RESPONSE TO REQUEST FOR FURTHER INFORMATION - 104-116 REGENT STREET, REDFERN

This letter has been prepared by Urbis on behalf of Wee Hur and relates to State Significant Development Application (**SSDA**) at 104-116 Regent Street, Redfern (**SSD-12618001**).

This letter responds to a Request for Information (**RFI**) issued by the Department of Planning and Environment (**DPE**) on 15 July 2022. DPE requested responses to additional submission by City of Sydney, Sydney Metro and one public submission following their review of the Response to Submissions (**RtS**) report submitted by Wee Hur on 15 June 2022.

DRAWING SERIES  
Overall Plans  
DRAWING TITLE  
Level 16 /Level 17 to 18

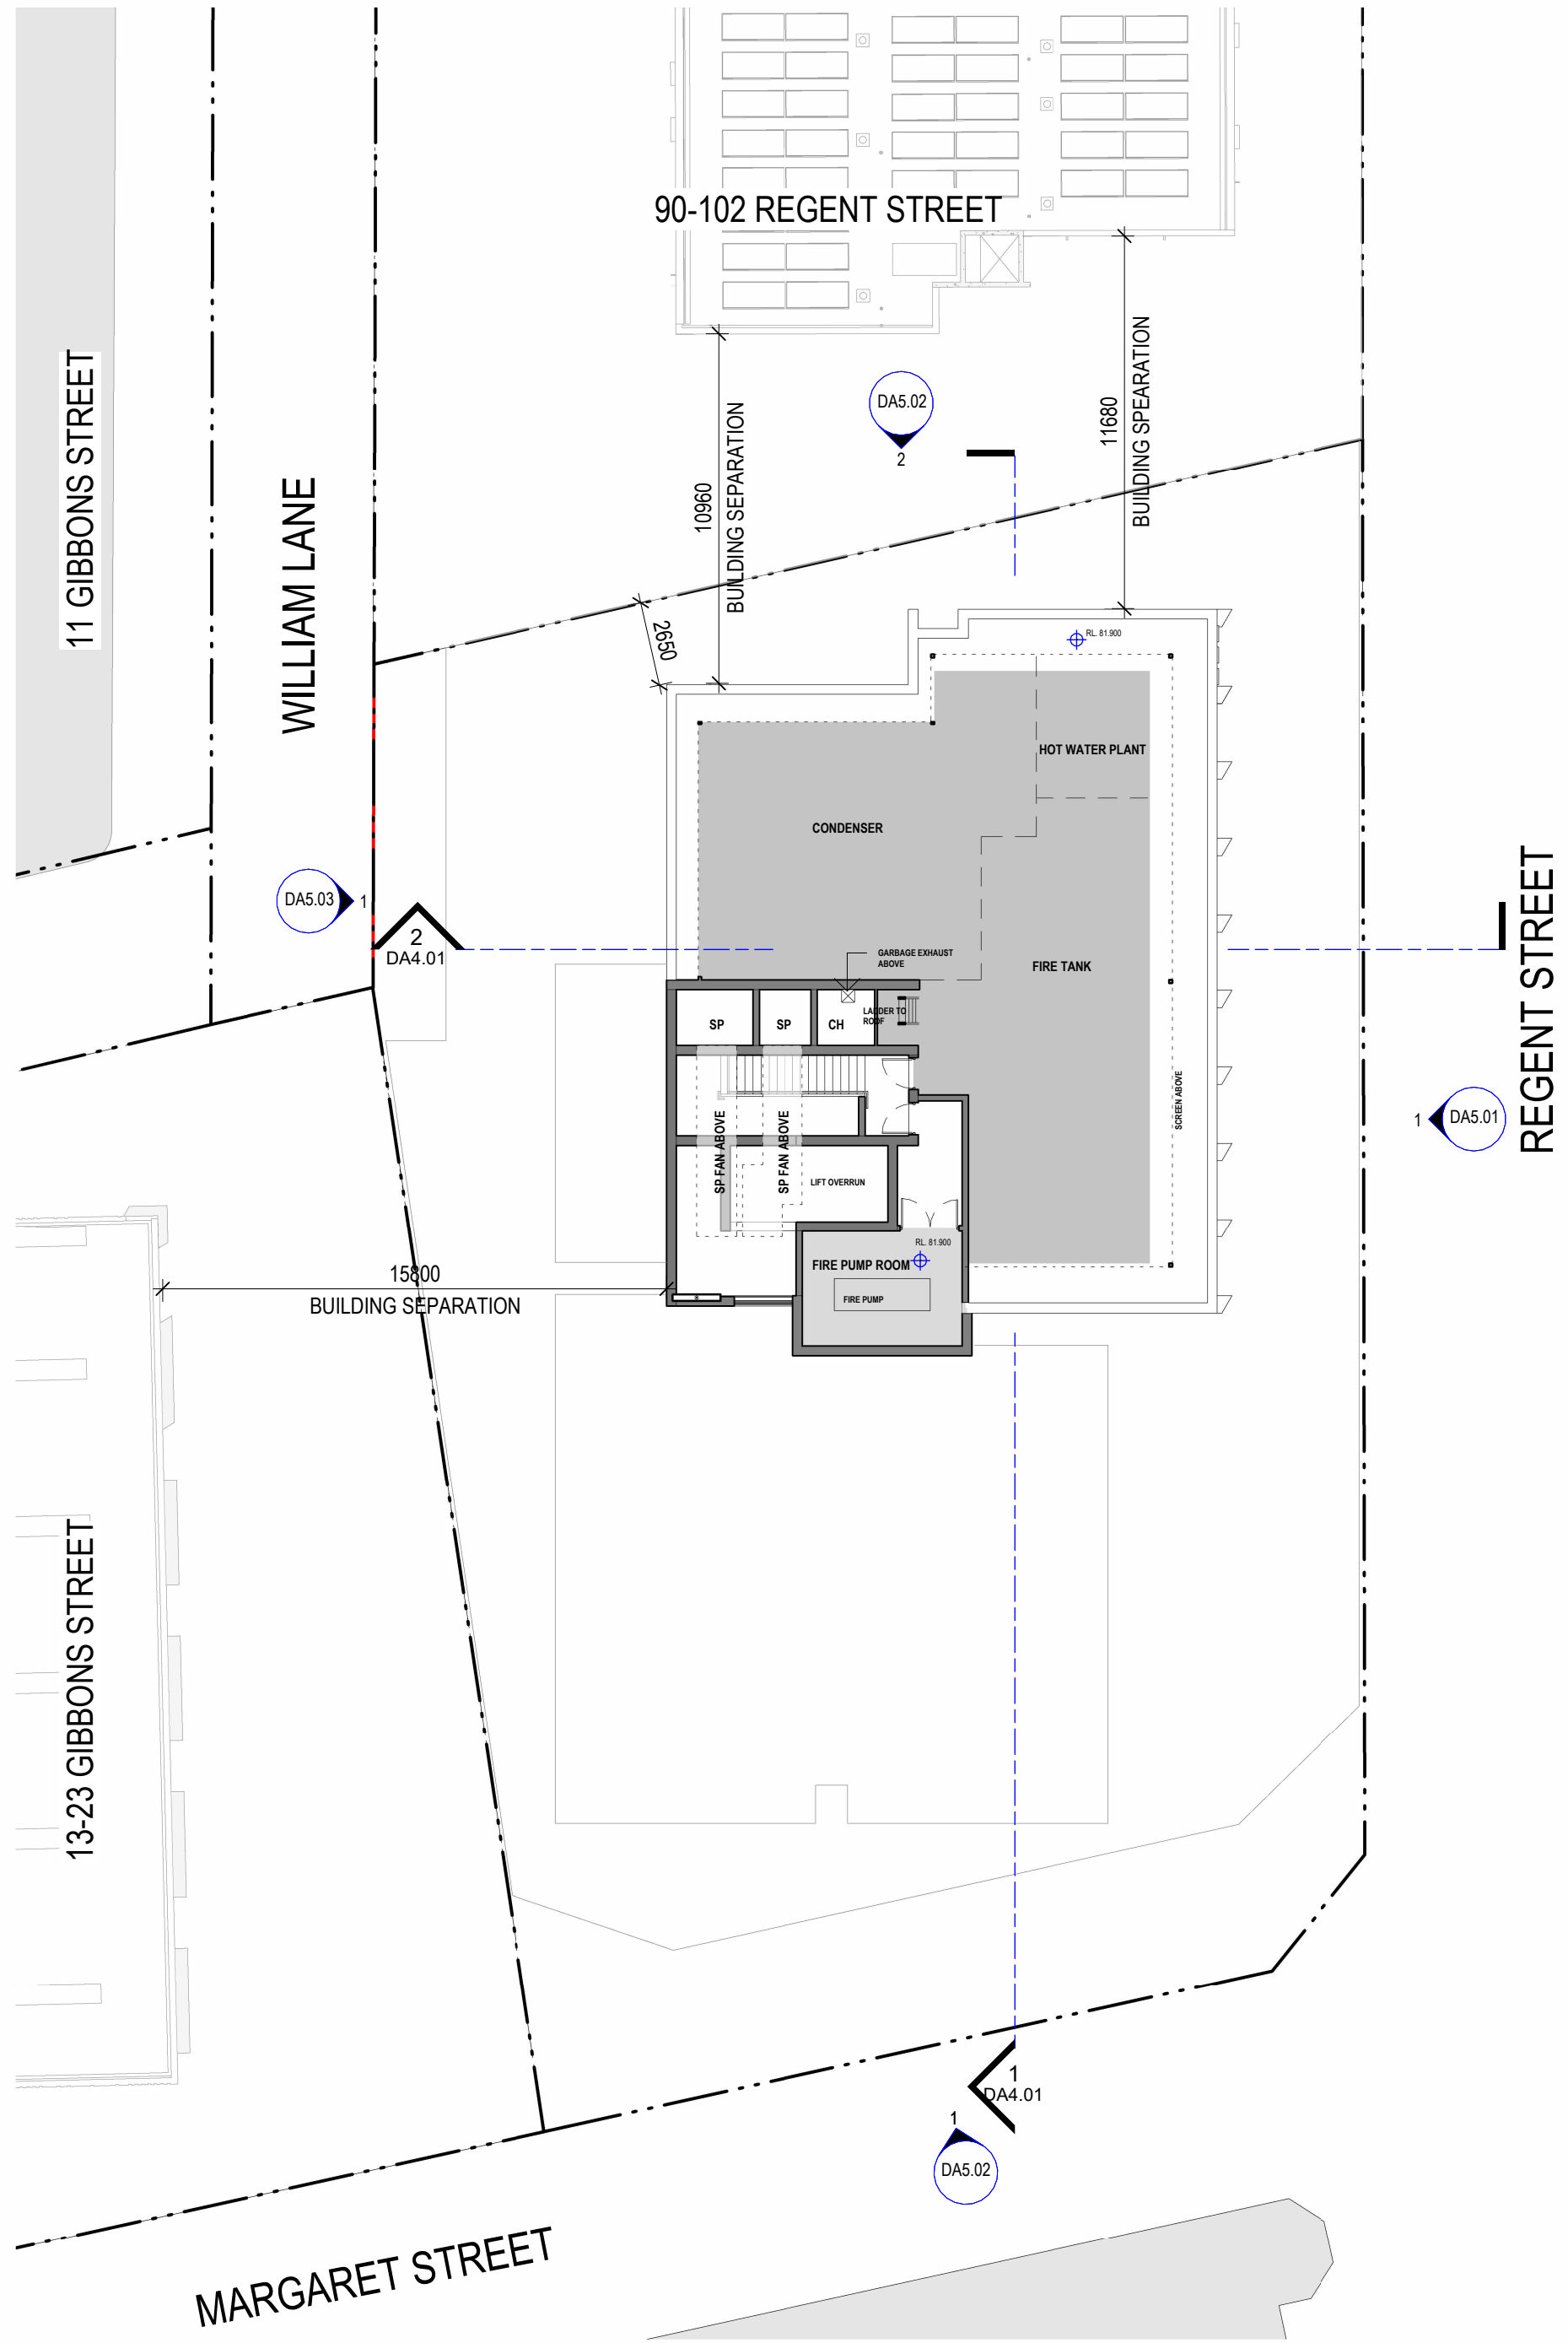
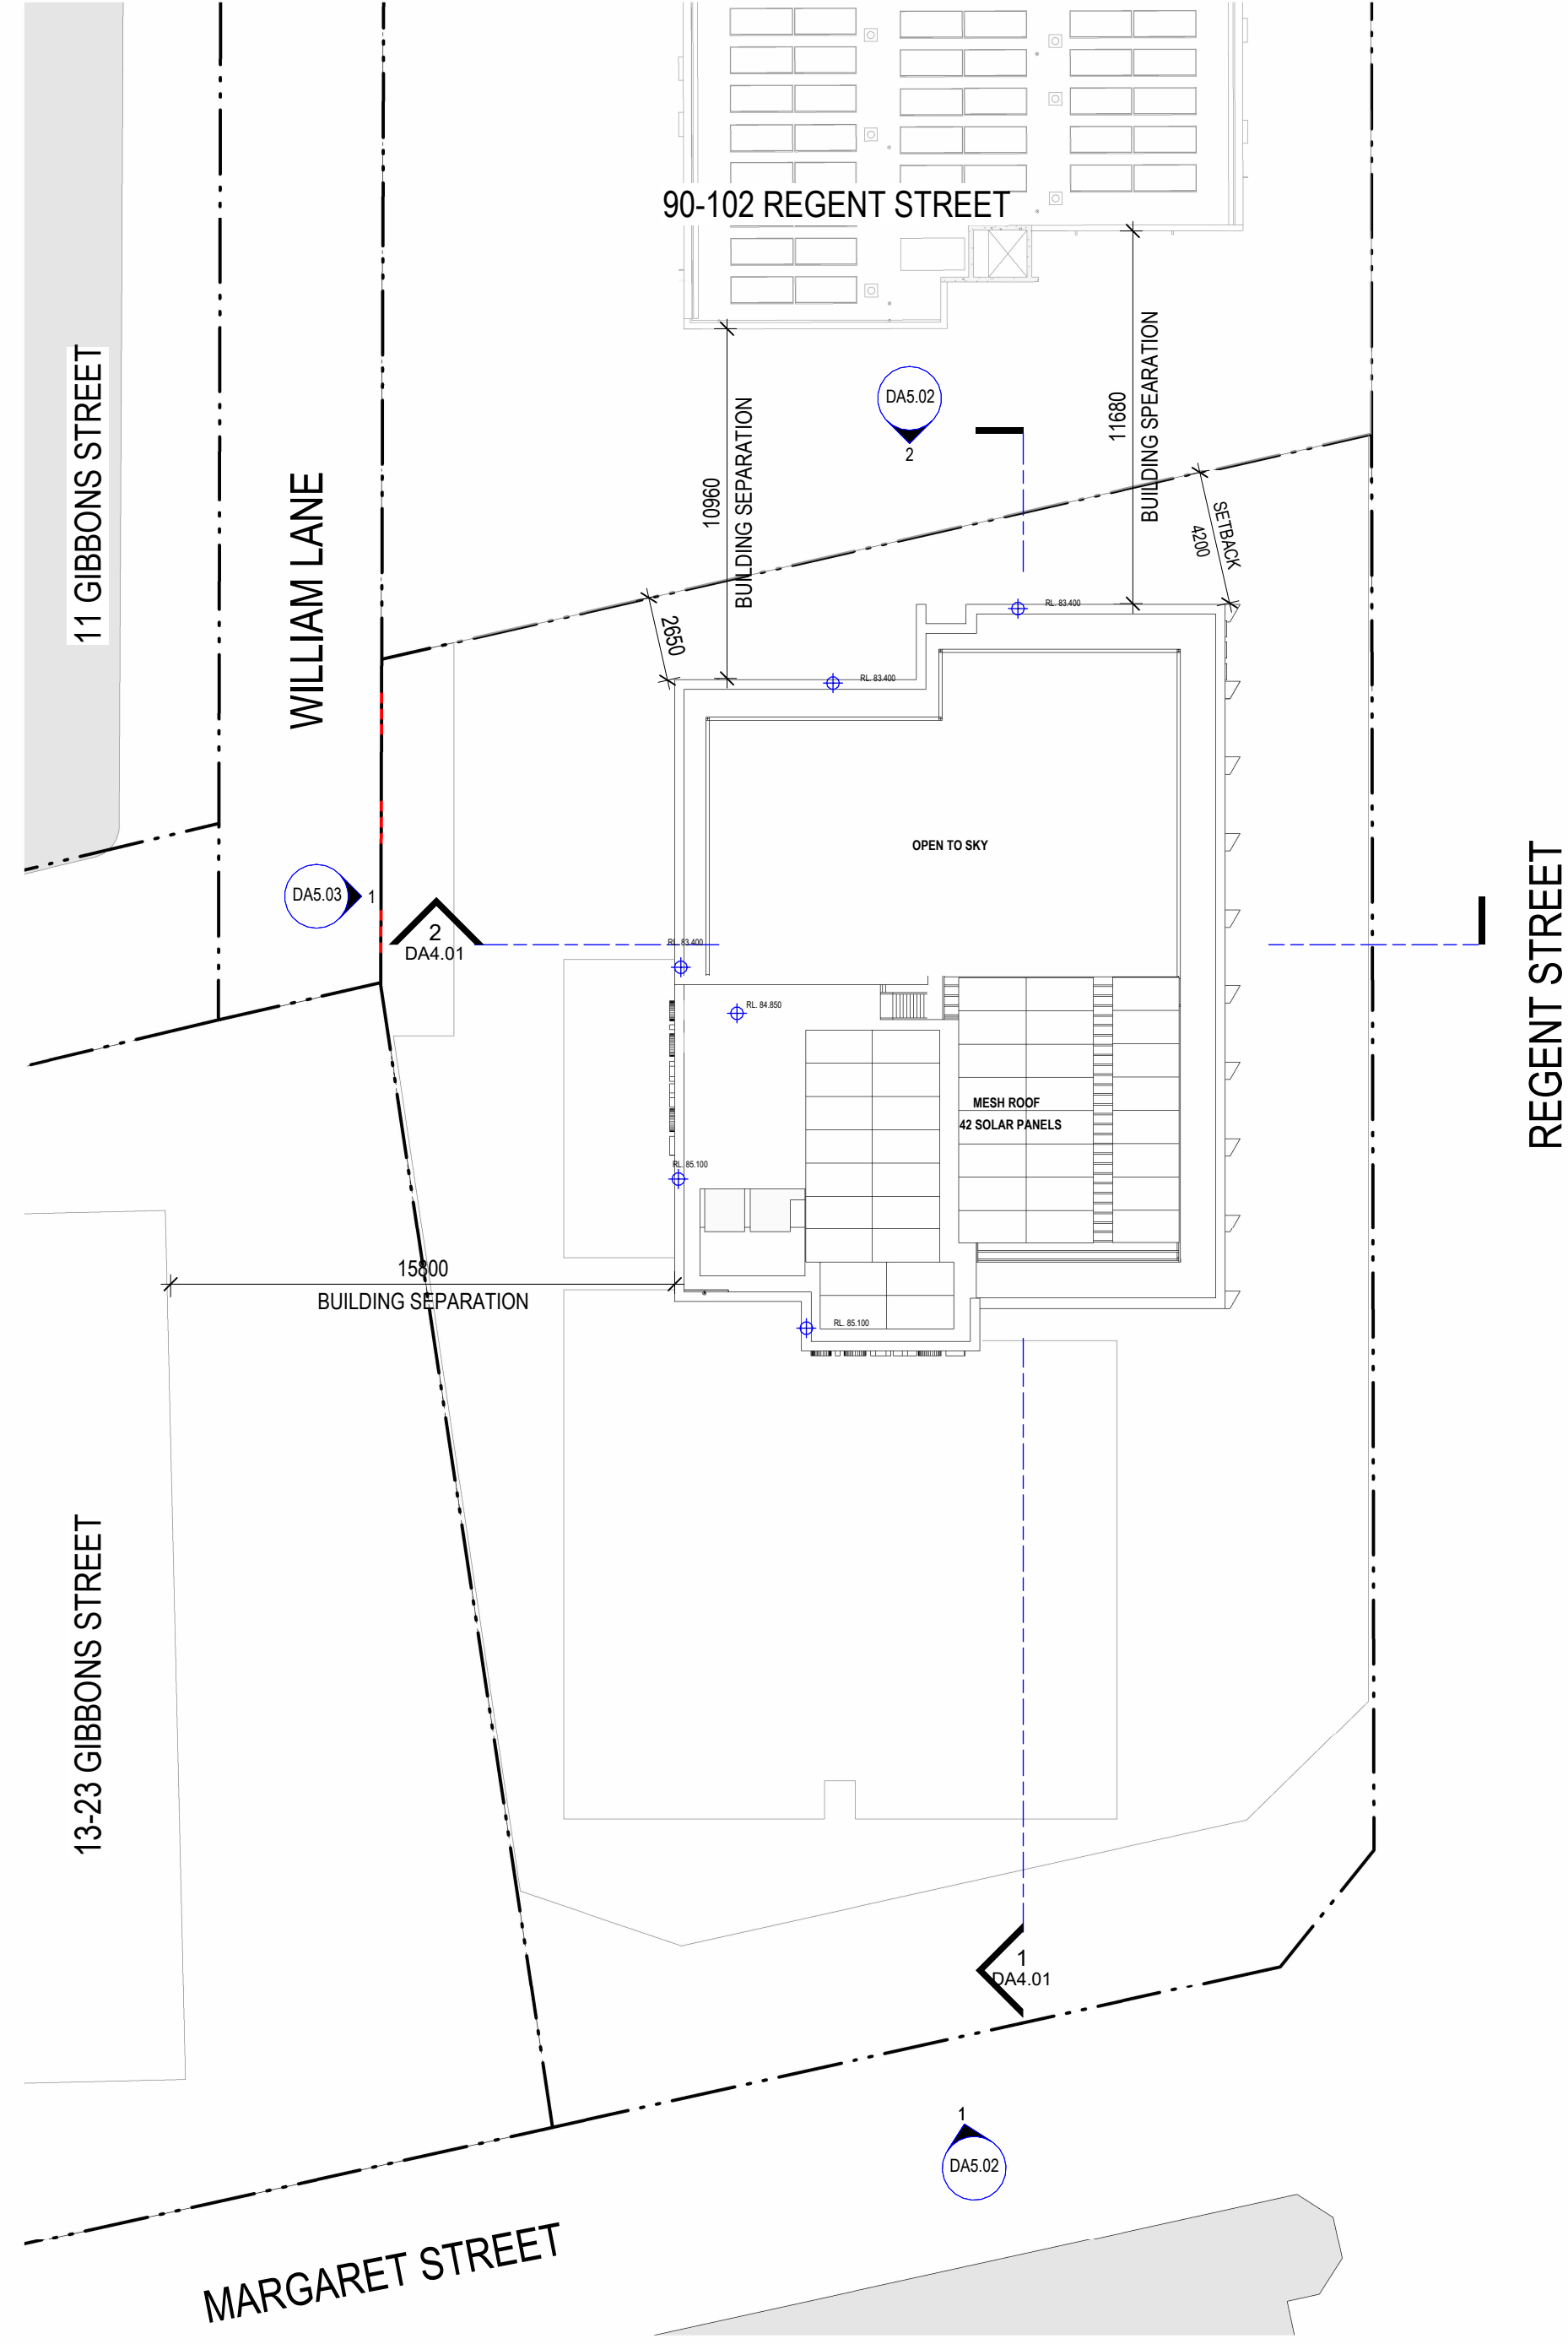
<p>Level 16 includes 10 trees at close centres located in a central integral planter 700mm high that rely on mounding to achieve minimum 1m depth required for tree planting. There are perimeter GRC planters with shrubs. No planting plans have been submitted, only a plant schedule. A reliance on living evergreen trees to mitigate wind on upper levels of a building is problematic if the trees</p>	<p>Each of the issues raised by Council has been addressed as follows:</p> <ul style="list-style-type: none"> The central landscaped planter will provide screening and shelter for students. The planter will contain planting of sufficient mature stock and the trees will be anchored both below and above ground.

Comment	Response
<p>fail. The design is a poor outcome and not supported from a landscape perspective.</p>	<ul style="list-style-type: none"> ▪ We will look at the option to increase the planter height to improve the volume of soil without mounding ▪ More detail has been provided of the planting species in the amended Landscape Plans at Appendix F. ▪ The design includes a deck area for functions/ events that is protected by the planter and vegetation. ▪ The perimeter planter has been redesigned to include a solid hedge with mature plants (25L) and additional larger shrubs at intervals. These will be protected by the perimeter architectural screening.
<p>Facade Greening</p> <p>The proposed facade screen is designed for wind protection and includes fragmented small planters integrated into the podium screen in gaps to the brick facade crisscross pattern. The plants appear to be growing out of thin triangular concrete shape with inadequate soil depth, no allowance for drainage and irrigation to support a successful green facade. To this effect, the City recommends that the planters on the facade screen be deleted.</p> <p>The landscape plans show a coloured concept planter elevation and plant species with notes for an 800mm wide x 650mm deep GRC planter behind brick facade. No planter detail has been provided. However, as proposed, there will be soil media at the planter centre point only. At the edges, there will be no soil depth and it is not feasible. Maintenance is proposed within the building, or for areas not on Level 2, on Regent Street from the public domain using a</p>	<p>The planters on the façade screen have been removed - refer to the amended Architectural Plans at Appendix D and Landscape Plans at Appendix F.</p> <p>The landscaping within the planters to the rear of the screen will be visible through the architectural façade. These planters ensure safe access for maintenance from the terraces.</p>
